# Planning Proposal

Record Number: 22/05371#62

[Planning Number: SSD-50629707](#)

## The Plains Wind Farm

**Crown Roads shown by light green colour**

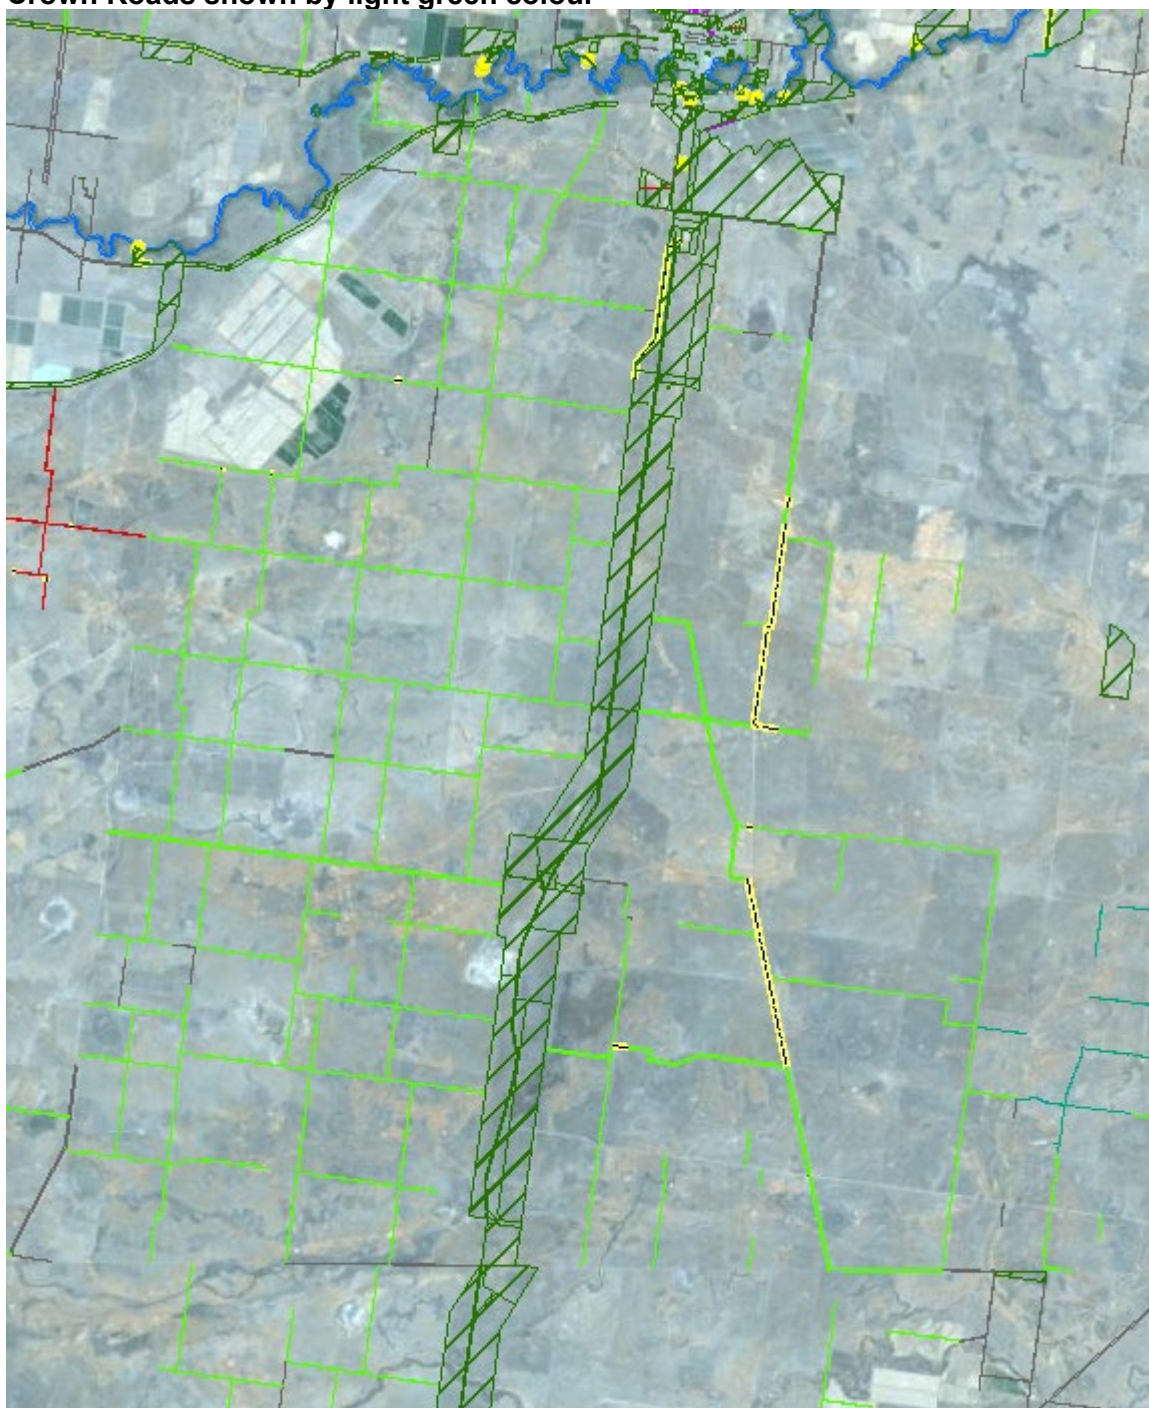
There are multiple Crown roads, including Crown roads with enclosure permits, both within and adjoining the proposed development area. Please refer to the attached map, where Crown roads are shown in green colour and Crown roads with enclosure permits are shown in yellow colour. Any Crown road required for access to the development/proposal, will need to be transferred to Council, or application made to close and purchase the roads. As authority to access or use Crown roads is required prior to the commencement of any works or access, and to avoid any delays for the proposal, a tenure may be required in the interim. More information regarding Crown roads and Enclosure permits can be found at the following links:
